Reference No:	2025/62/90493/W
Site Address:	11, Town End Avenue, Wooldale, Holmfirth, HD9 1QW
Description:	Demolition of existing garage and erection of two storey side extension, single storey garage extension and associated driveway
Recommending Officer:	Joshua Merriman

DECISION – CONDITIONAL FULL PERMISSION

HOUSEHOLDER DELEGATED REPORT

DRAWING TITLE:  
Layout Plans

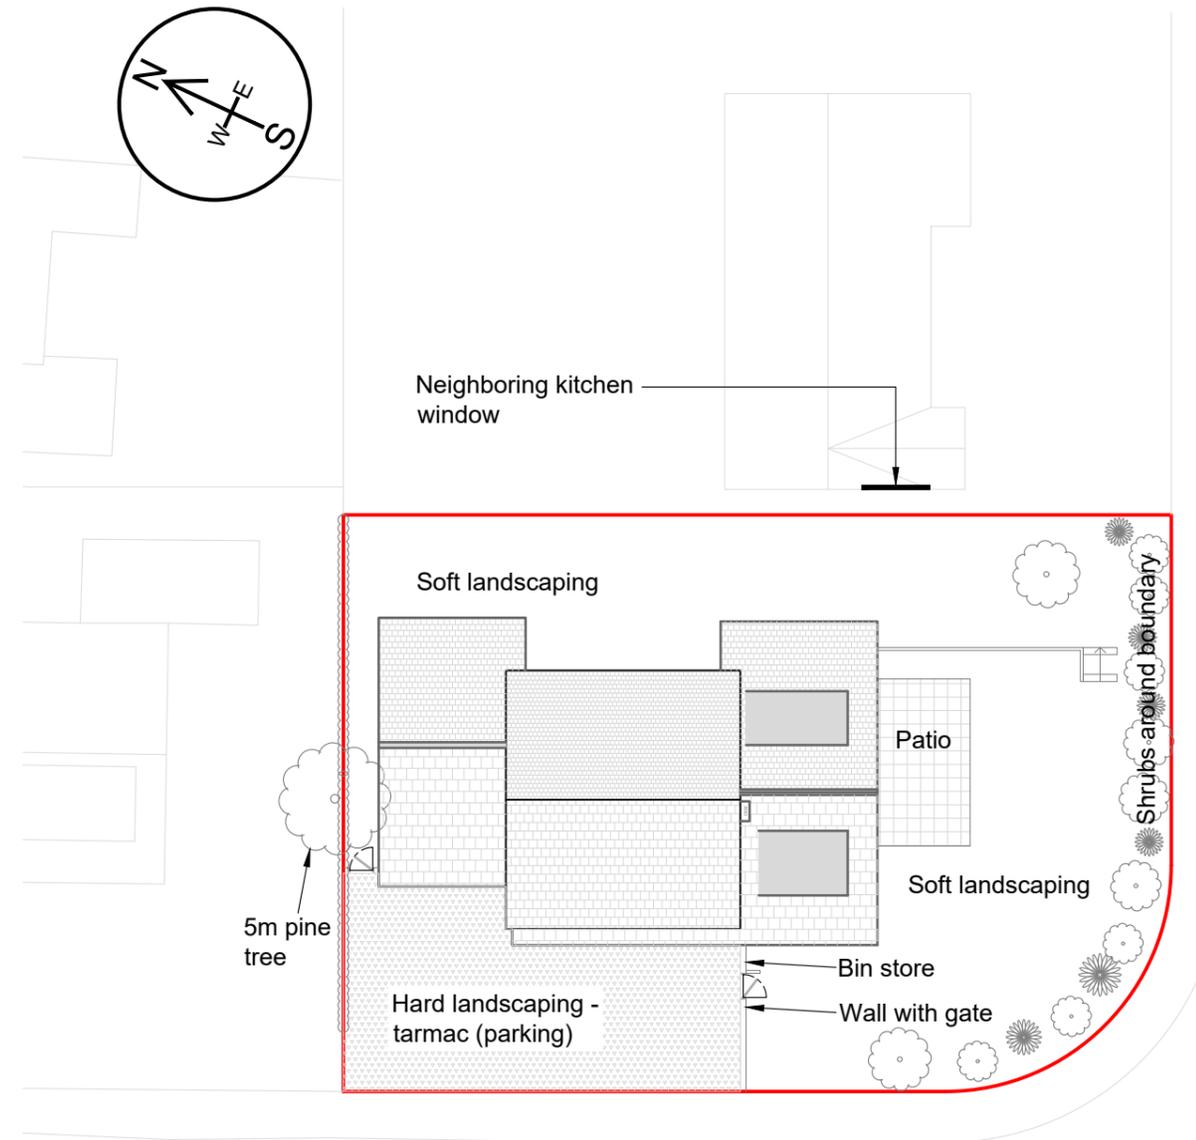
render to external walls – Conditional Full Permission.
Consultations required	Yes	KC Highways (Informal) – Due to the proximity of the proposed new access to a blind bend, it is necessary that the new access is located further away from the bend. Consequently, the applicant submitted new plans to ensure the new dropped curb was located further away from the ‘blind bend’, and this is considered acceptable.

Relevant key design principle (KDP) of the SPD, Policy in the Kirklees Local Plan and the NPPF	Further comments	✓ / X / N/A
Impact on highway safety	<ul style="list-style-type: none"> • KDP 15 of the SPD • Policy LP22 Parking (f) of the KLP • Chapter 12 of the NPPF 	As the extensions are well set back from the nearest highway (Town End Avenue) it is considered that there will be no significant impacts upon highway safety.	✓
Parking provision	<ul style="list-style-type: none"> • KDP 15 of the SPD • Policy LP22 Parking (f) of the KLP • Chapter 12 of the NPPF 	The submitted plans propose an increase in off-street parking to the front of the property, allowing for three off-street spaces on the application site. Furthermore, following the movement of the proposed new access away from the blind bend	✓

to the North West of the property, the parking provision at the dwelling can be considered acceptable as this meets the relevant demand for the dwelling.	
Provision for waste storage	<ul style="list-style-type: none"> • KDP 16 of the SPD • Policy LP24 Design (d) (iv) • Chapter 12 of the NPPF 	The waste storage detailed within the submitted plans is considered to be in acceptable location.	✓

following an informal consultation with KC Highways resulting in this being considered too close to a blind bend situated to the North West of the dwelling. The applicant since submitted new plans situating the new dropped curb further away from the blind bend, and this is considered acceptable from a highway safety standpoint. Furthermore, the case officer sought it necessary to request an additional window in the side elevation of 'bedroom 4' to increase the natural light into the room. Following this, the applicant submitted amended plans including the desired window, making the plans acceptable in this regard.

DRAWING TITLE:
Elevations, Sheet 1 of 2

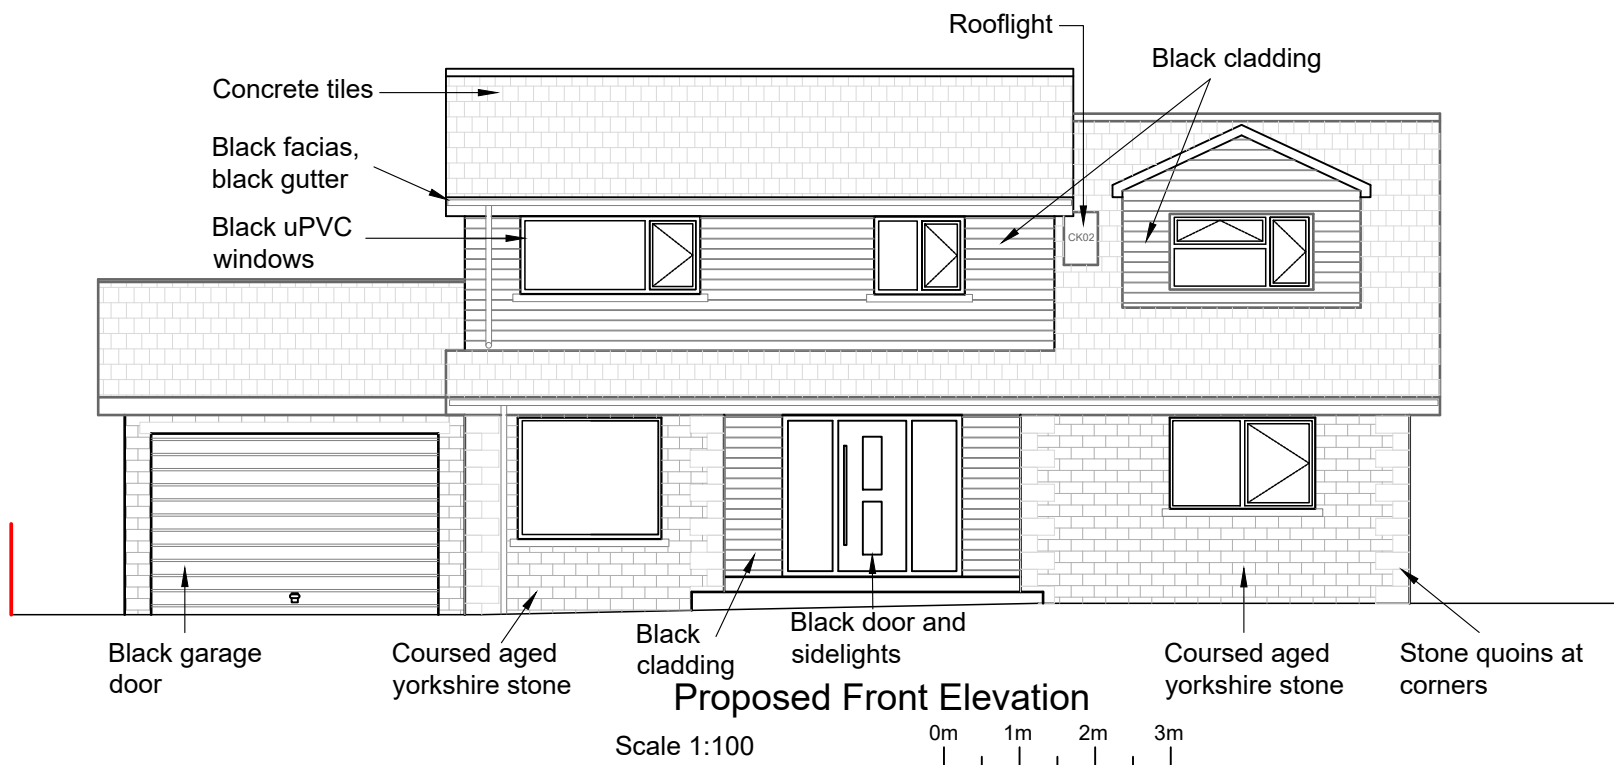
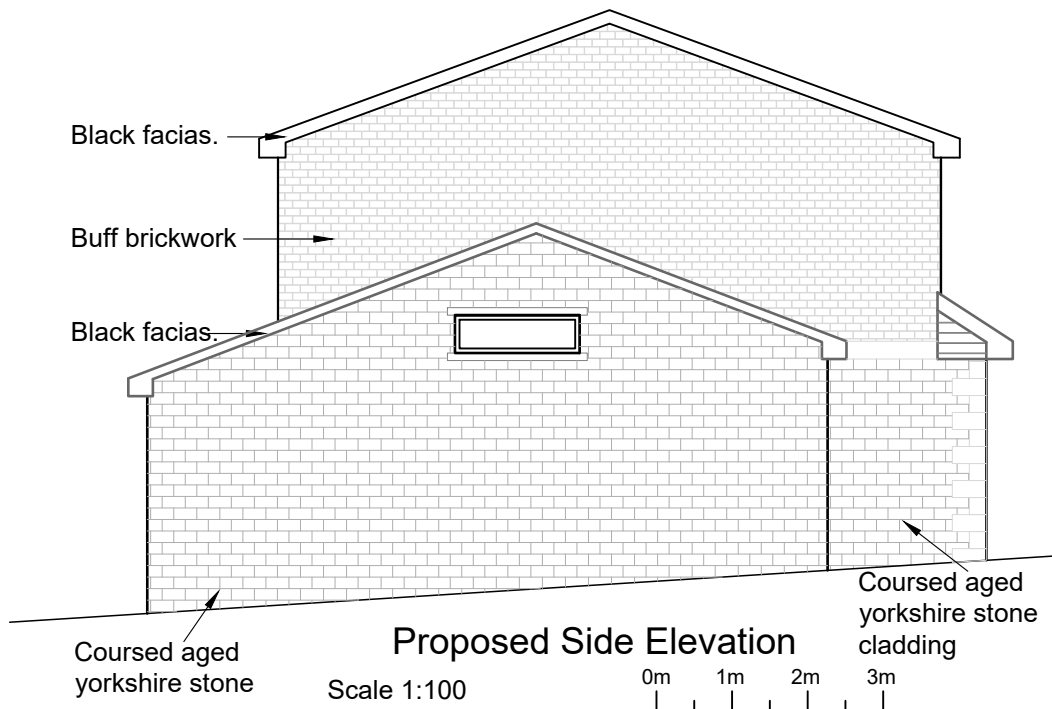
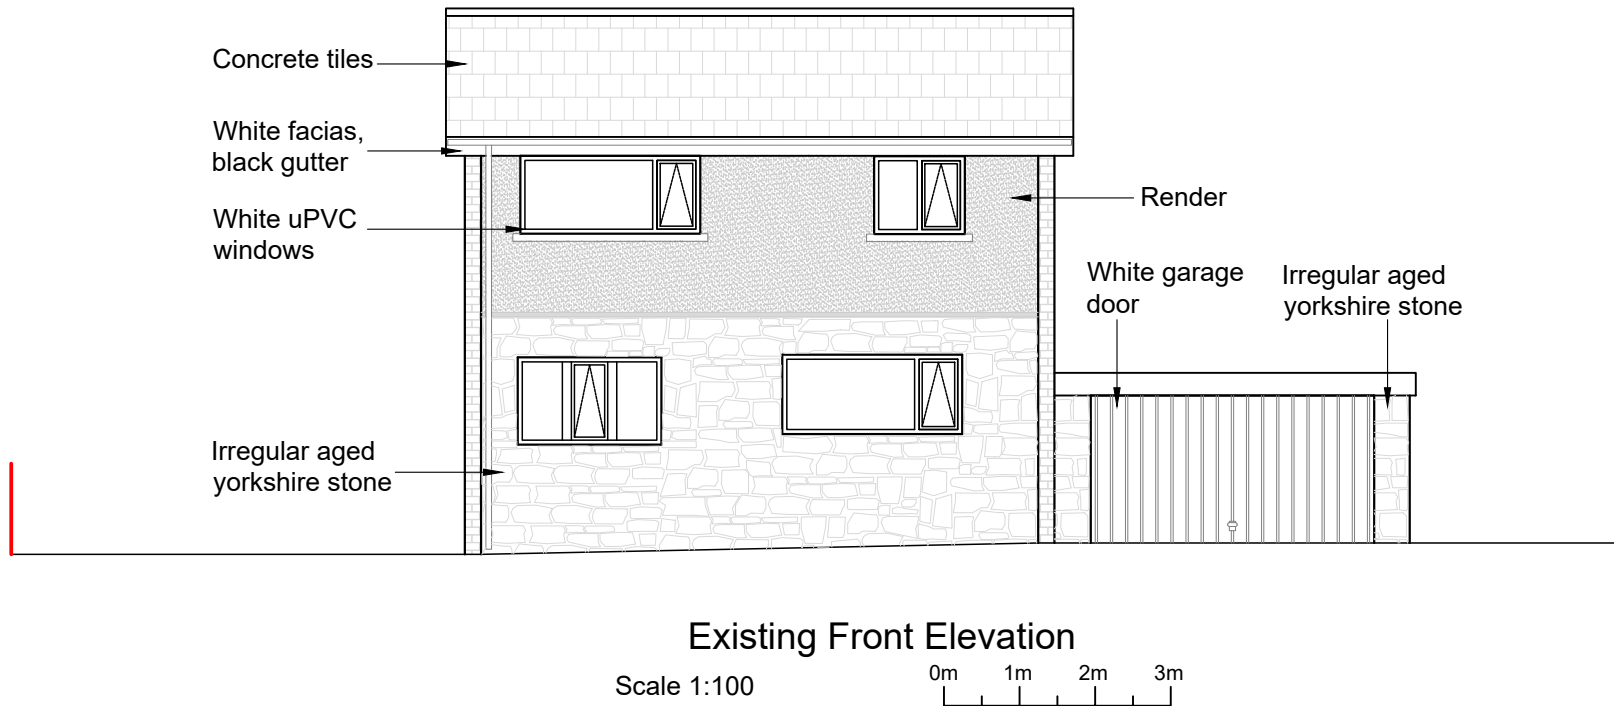
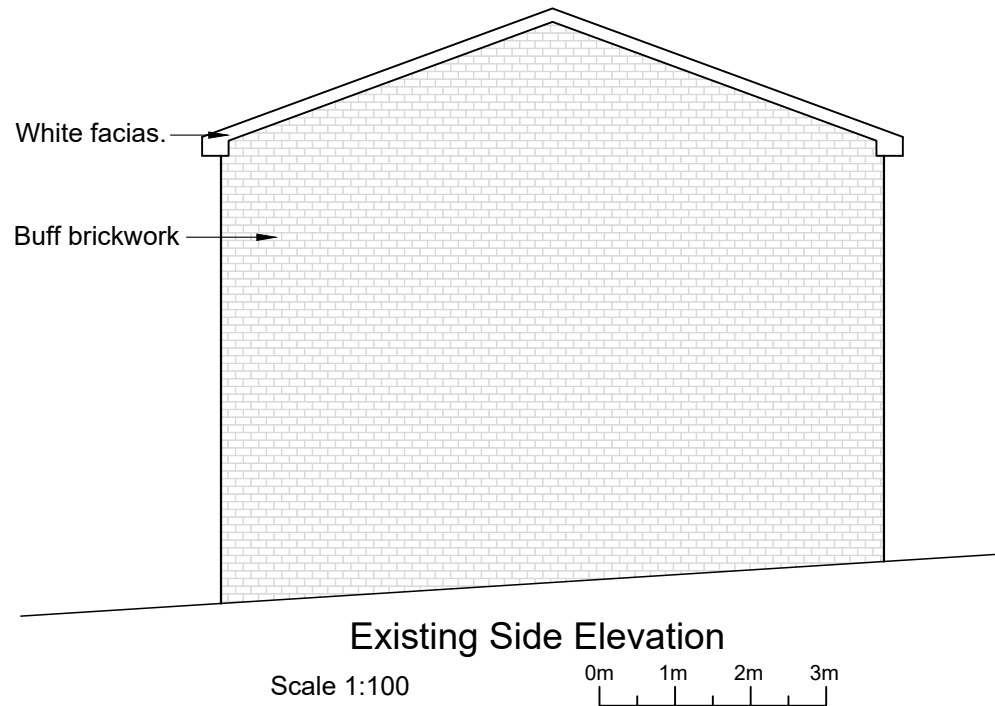
Moreover, the proposed front dormer will project 2.45m from the roof plane of the existing building, with a maximum height of 2.37m, eaves height of 1.29m, and a width of 3.6m.

relate to the appearance of the house and existing roof	The proposed front dormer relates to the house and existing roof in terms of size, scale, and materials.

be designed in style and materials similar to the appearance of the existing house and roof	The dormer is considered to be designed in a style and with materials that are sympathetic to the appearance of the existing house and roof.	
not dominate the roof or project above the ridge of the house	The dormer is subservient to the original roof and does not dominate the roof.	
be set below the ridgeline of the existing roof and within the roof plane	The extension is set below the ridgeline of the existing roof and entirely within the roof plane.	
be aligned with existing dormer windows on neighbouring properties in the same roof plane where relevant	The extension will be aligned with the rear dormer on the proposed two storey side extension but otherwise has no neighbouring dormers to be aligned with.

the proposed ensuite window in the front dormer is obscured, it is considered that there will be no material impact on the privacy of neighbours.	
Impact on light and outlook of neighbours (to sides, rear and front)	<ul style="list-style-type: none"> • KDP 4, 5, 6 of the SPD • Policy LP24 Design (b) • Chapter 12 of the NPPF 	<p>Number 6 Town End Crescent is set down from the application site. Although the proposed two storey side extension may have some impact on the light to the side kitchen window of 6 Town End Crescent the space maintained along with it not serving a non habitable room, it is considered that the impacts will not be material enough to justify refusal.</p> <p>Due to the scale and positioning of the development as well as relationship of windows to neighbouring dwellings and associated amenity space, there are no concerns regarding a loss of amenity.</p> <p>The development is considered acceptable in this regard.</p>	✓

4. The proposed ensuite window in the South West facing elevation shall be fitted with obscure glazing to at least Level 3 on the Pilkington Scale (or equivalent) and be non-opening to a height of no less than 1.7m above floor level and retained as such thereafter.
